From: Charles Stanton [REDACTED]
Sent: 23 April 2026 13:03
To: Ben Taylor
Subject: Re: 3/2026/0053

and PL02 rev C with the actual lighting arrangement, this reduced the number of fittings from 22 to 15 as we concerned that the layout would be too bright.

**B** Proposed Floor Plan  
1:100

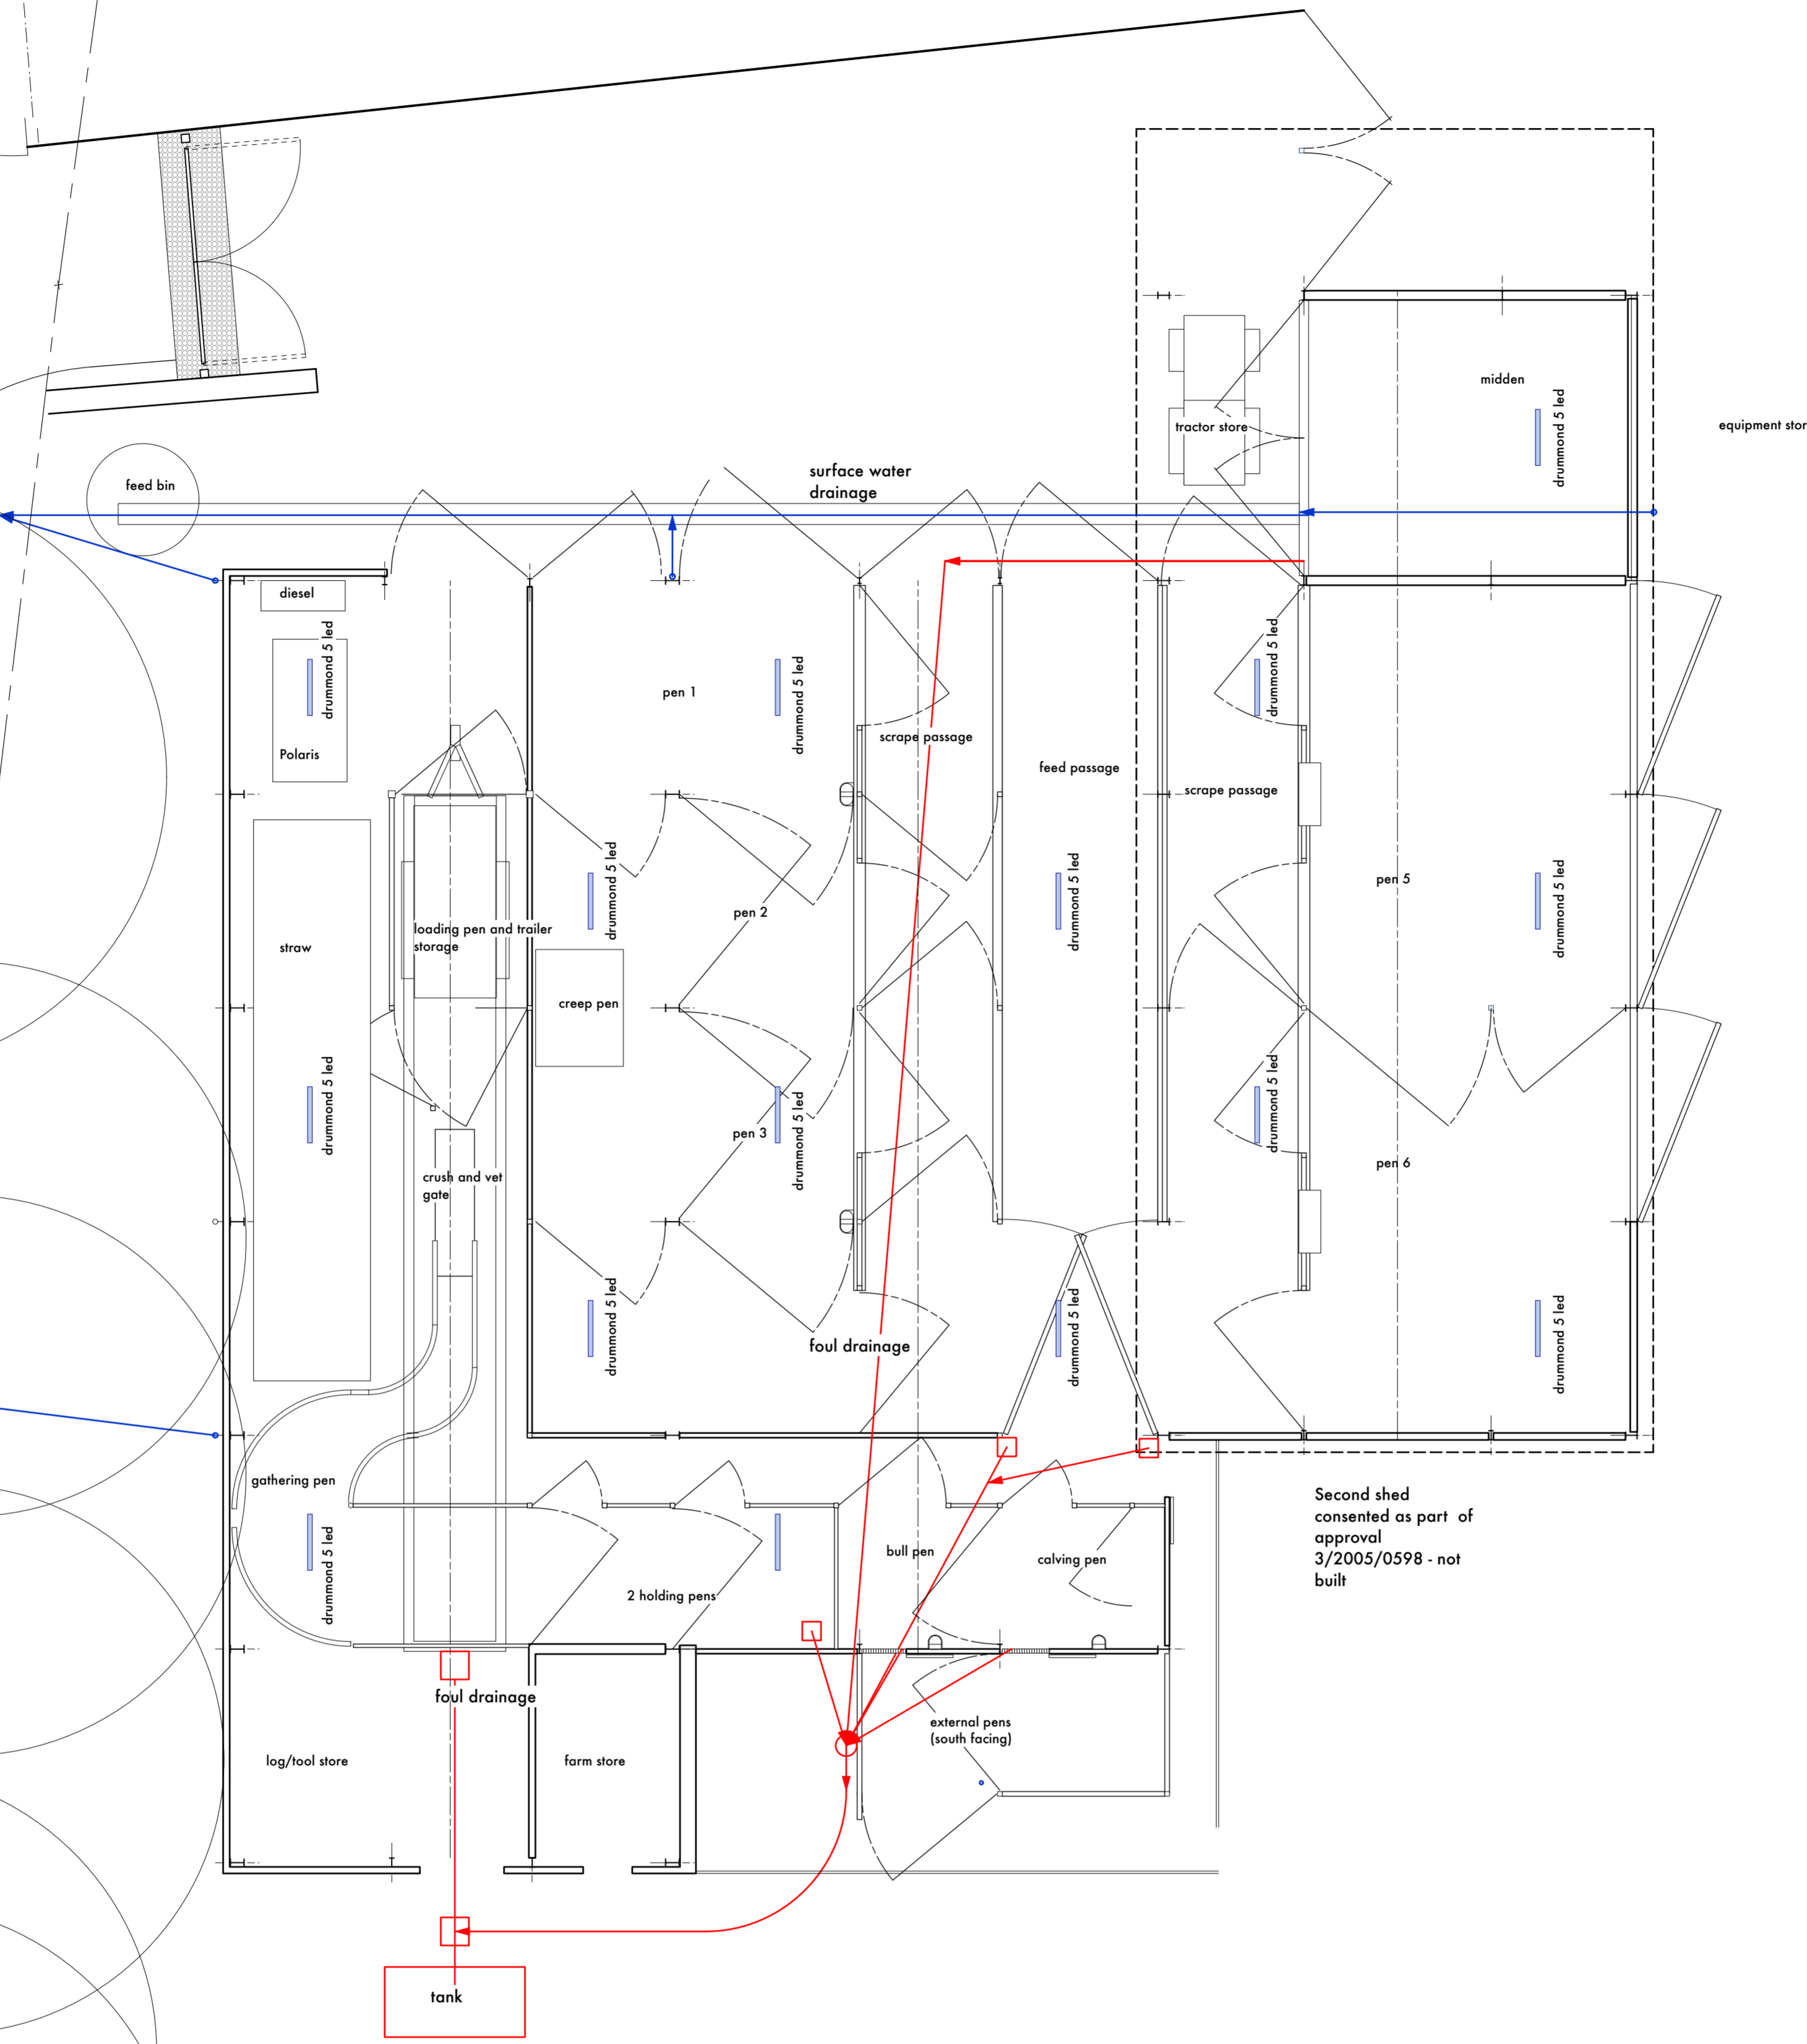
The lighting is programmable and is designed to come on from 6am to 8.30am and from dusk to 9pm. The lamp fittings include a 10W red light which we can use at night time if we want to want walk amongst the stock without disturbing them. Cows can't see red light apparently.
